From: Jennifer Thompson
To: Jean Fraser; Jeff Tarling
Date: 4/17/2014 2:57 PM
Subject: Re: UPDATE: urgent - final Plat 118 Congress for PB signing 4.22.2014

This revised plat was submitted this AM as final (first attachment).

SUBDIVISION RECORDING PLAT

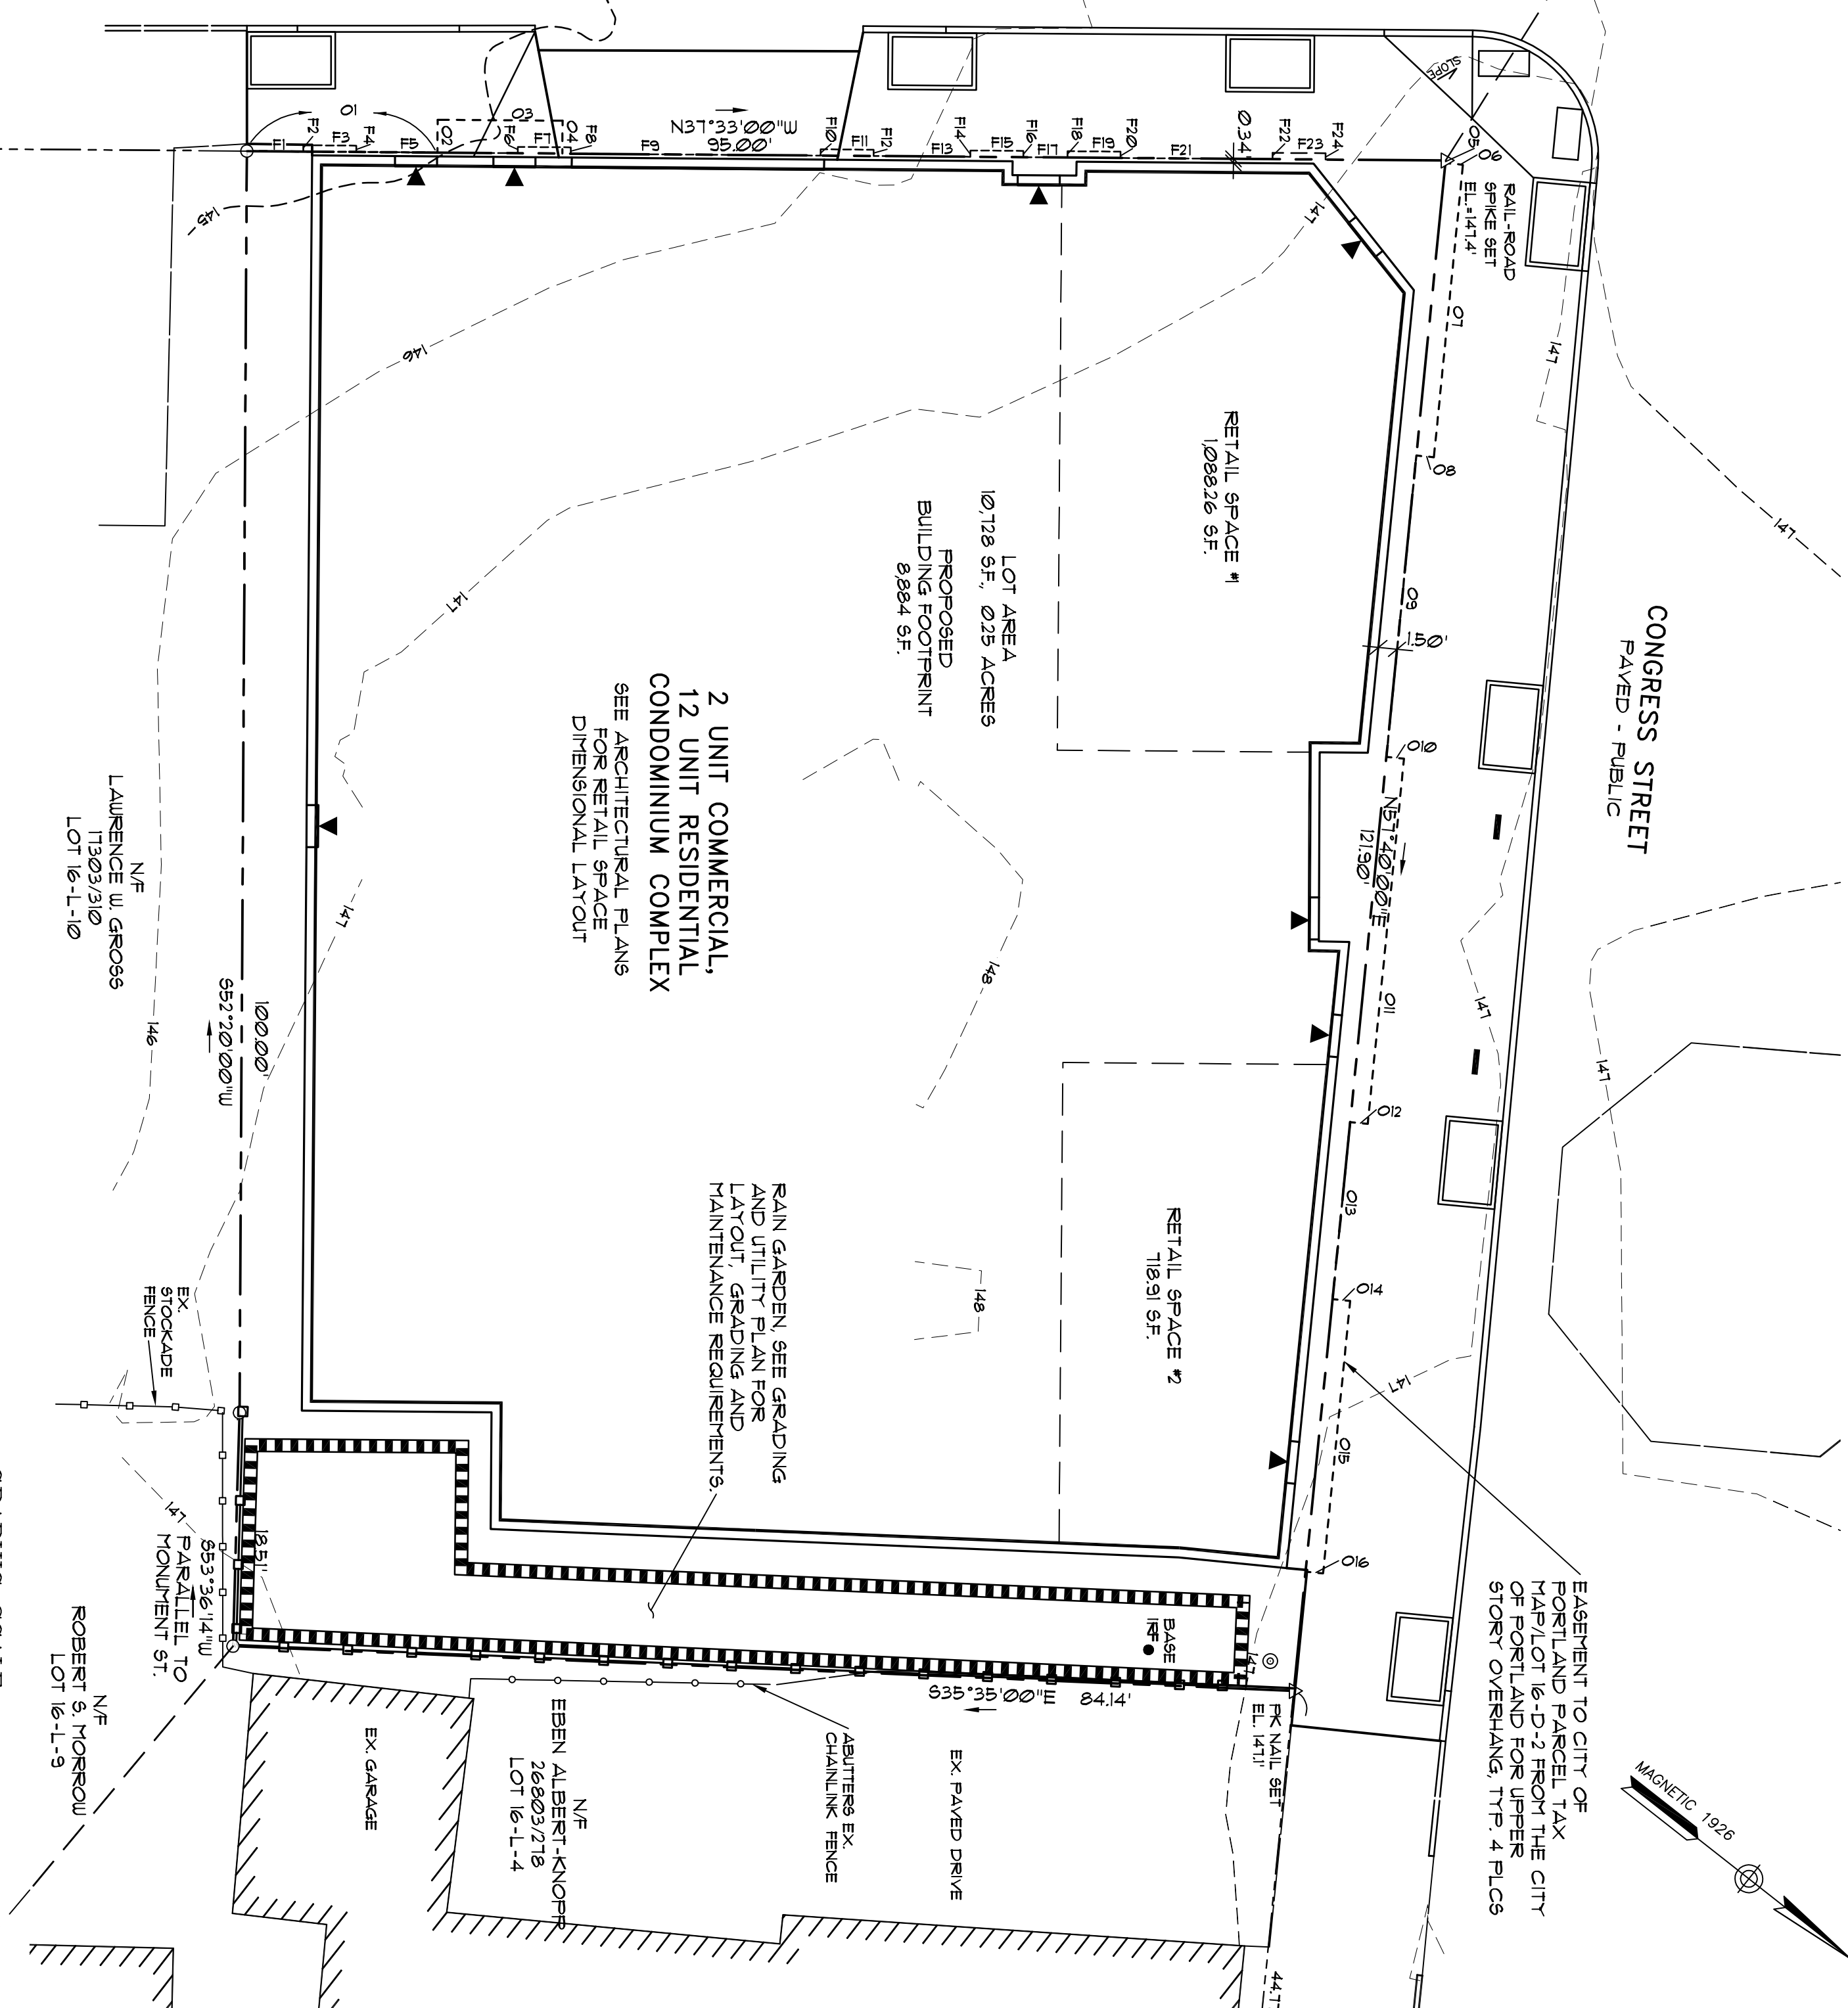
This appears to address my concerns - except that the condo docs have not been referenced by book and page.

Jen and Jeff- I have told them that we need the info that Jeff has requested (from long ago; in approval letter and recently) that supports the street tree locations before we can sign off on the plat. Re the plat I wonder if we could live with them adding the following note instead:

"The location of street trees are approximate and final locations will be subject to documented agreement with City Arborist prior to the issuance of a building permit".
